<b>Consultation Response from: KC Environmental Health (Pollution &amp; Noise Control)</b>		
<b>2023/92448 Former Cooper Bridge Water Treatment Works, Leeds Road, Huddersfield, WF14 0BT</b>		
<b>Outline application for erection of B8 industrial unit</b>		
<b>Date Responded:</b> 11 <sup>th</sup> September 2023	<b>Responding Officer:</b> RM, NH, MN	<b>Responding Ref:</b> WK/202327411
<p>The outline application seeks approval for a 27,500m<sup>2</sup> warehouse with a maximum height of 24m. The site is located on the former Yorkshire Water Treatment works. This was previously a series of filter beds and adjoins the existing John Cotton factory on Leeds Road and is allocated for employment development within the Kirklees Local Plan (site ES9). There are two houses located immediately to the western site boundary and houses 130m away from the eastern most tip of the site.</p> <p>We have reviewed the application and supporting information and make the following comments and recommendations.</p> <p><b>Air Quality</b></p> <p>An Air Quality Assessment (ref: J0737/1/F1) (dated: 22<sup>nd</sup> August 2023) by Air Quality Assessments Ltd has been submitted in support of the application. The s

Figure 1 – Proposed Development Layout

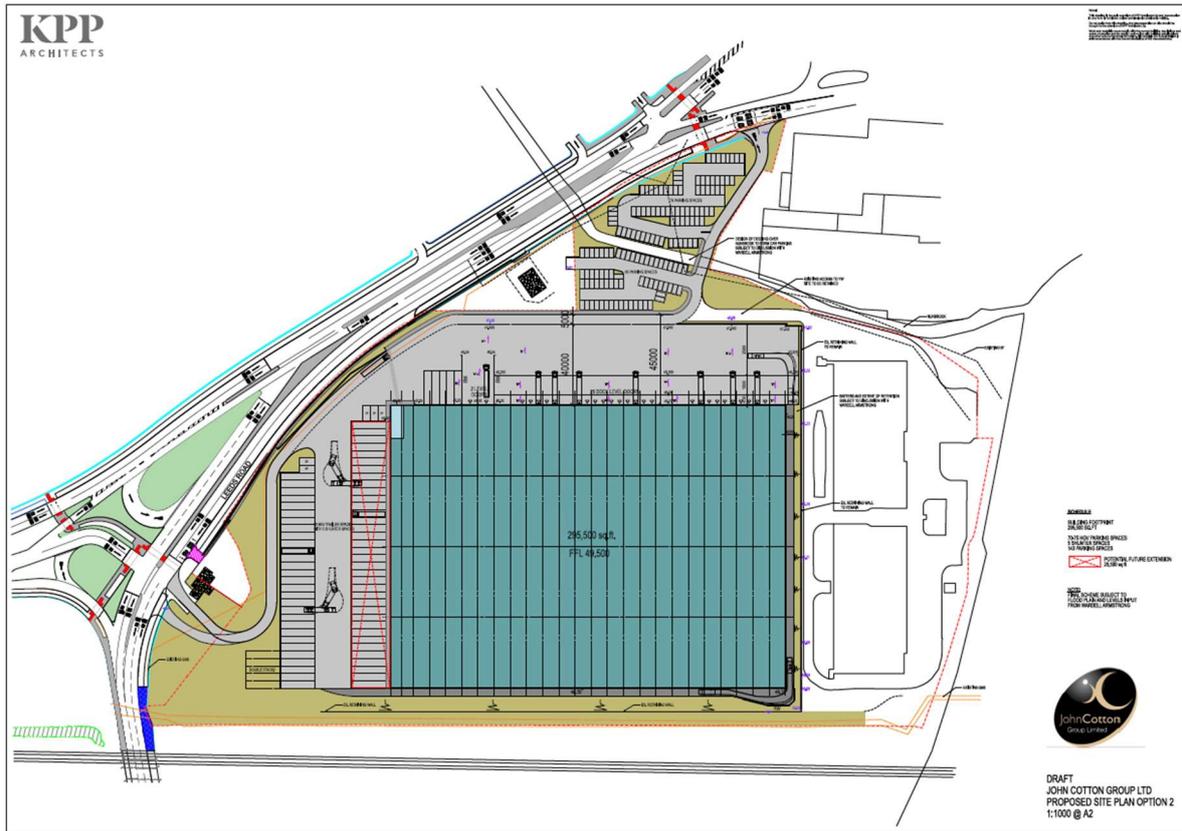
It is noted the proposed layout shown in figure 1 within the NIA differs from the submitted site plan from KPP Architects dated June 2023 Ref 2172 with particular reference to the Leeds Road/Cooper Bridge Road junction and the applicant is advised to ensure the correct site plan/layout is referred to in any submitted information.

Figure 2 – Measurement Locations and Site Surroundings

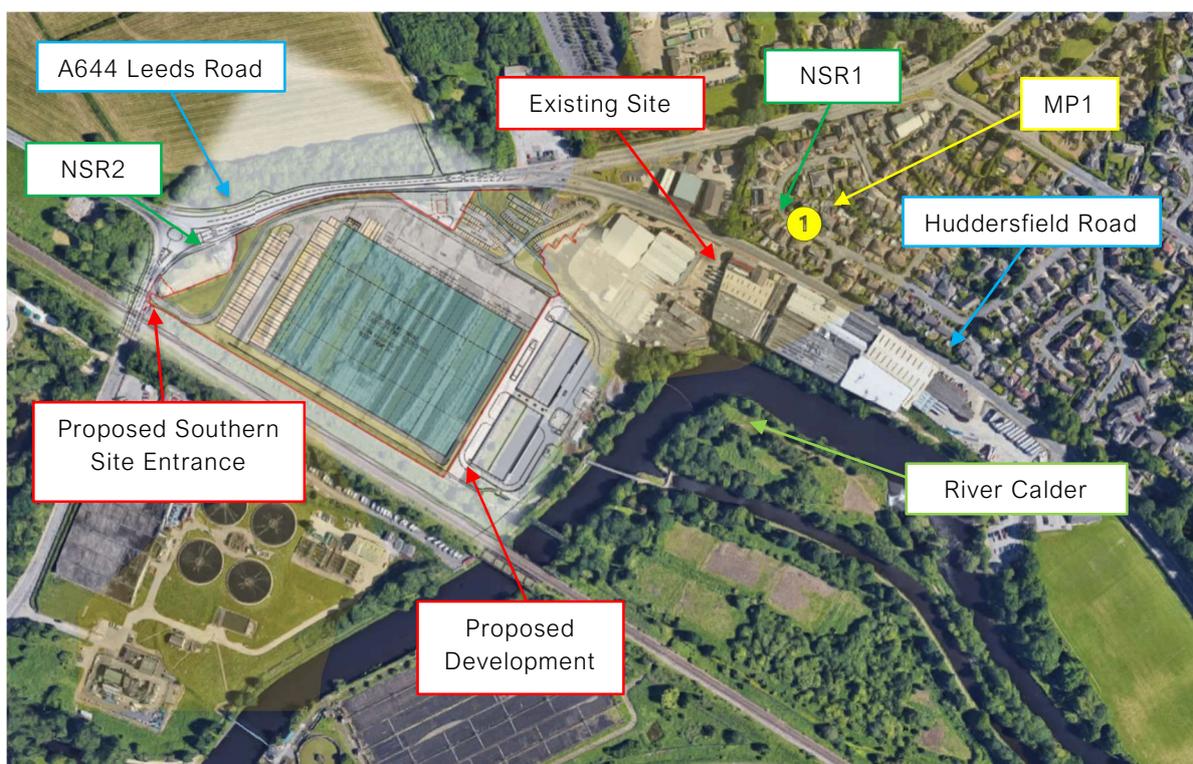
A noise survey was undertaken between 07 March 2023 and 09 March 2023 from one measurement position as shown in figure 2 to establish the prevailing background sound levels. Figure 2 shows the nearest Noise Sensitive Receptors (NSRs) to be on Huddersfield Road completely overlooking the properties at the Leeds Road/Cooper Bridge Road junction (Rose Cottage, 2 & 2A Leeds Road) which are immediately adjacent to the site. This is

All modelling and predictions within the submitted NIA are based upon the impact to the occupiers on Huddersfield Road and therefore, the report is rejected. A further/addendum report will be necessary. **This is required before the application is determined.**
